Application Ref:	3/2024/0758	 Ribble Valley Borough Council www.ribblevalley.gov.uk	
Date Inspected:	27/11/24		
Publicity Expired:	18/12/24		
DELEGATED ITEM FILE REPORT:		Decision	REFUSAL

Development Description:	Change of use from a mixed use within Class F1(a) and Sui Generis use as a Wedding Venue for up to 40 days a year to Sui Generis use as a Wedding Venue for up to 100 events a year.
Site Address/Location:	The Outbarn Clough Bottom Rabbit Lane Bashall Eaves BB7 3NA

Site Plan
(1:1,250)

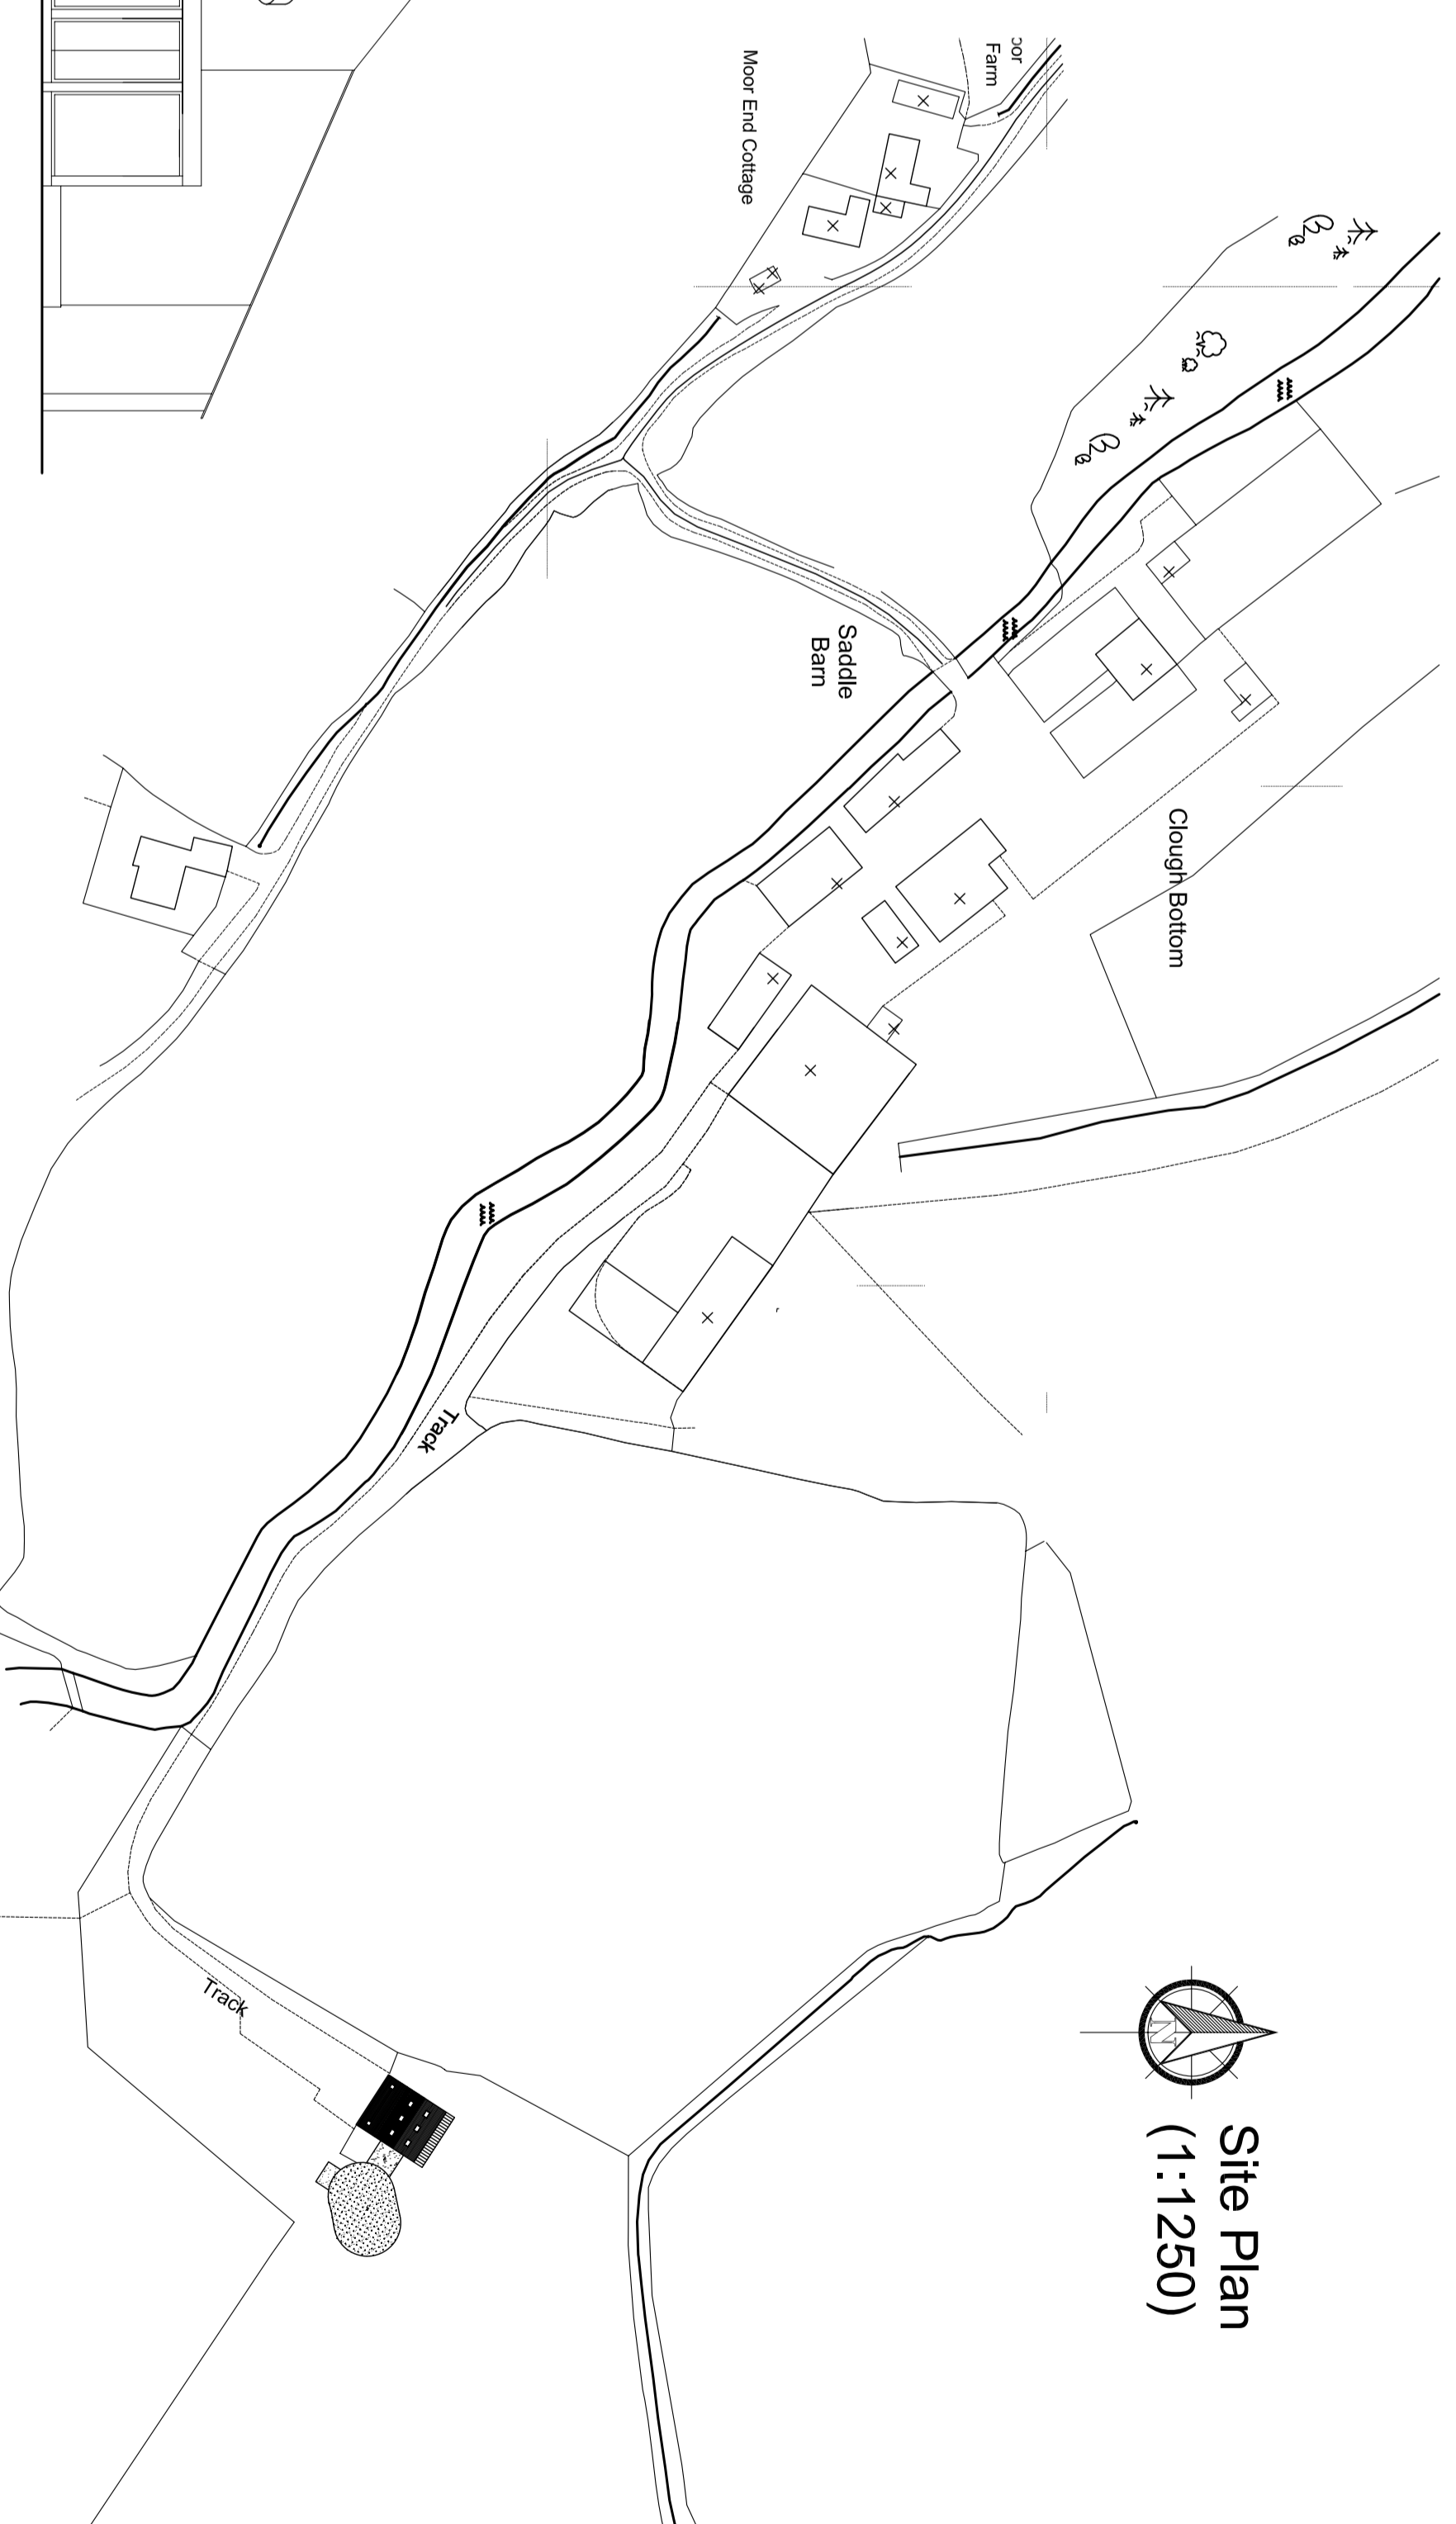
In particular, the one-way system previously conditioned as part of application 3/2016/0243 (condition 7 discharge application 3/2017/0367) has not been adhered to and this together with the limited signage and erection of gates discourages vehicle movement along the one-way system to the detriment of highway safety.

The Local Highway Authority are wanting to see significant improvements through the one-way system to ensure self-enforcement including more effective permanent signage which allows for easy viewing in darkness. While the site is currently meant to have 3 signs in place, no such signs were noted to be in place during a site visit therefore improved signage is required, with the one-way system clearly identified at the entrance point, entering and leaving the parking areas and at any further junction points along its route.

Scaled drawings of the signs to be permanently in place along the internal private road network need to be provided together with a plan indicating the direction of the flow of traffic through the site and the placement of the signs.

Moreover, the applicant should consider if a one-way system is still the most suitable and appropriate route through the site. The application should provide an explanation of why the one-way is not being implemented and make alternative suggestions which supports two-way traffic through the site.
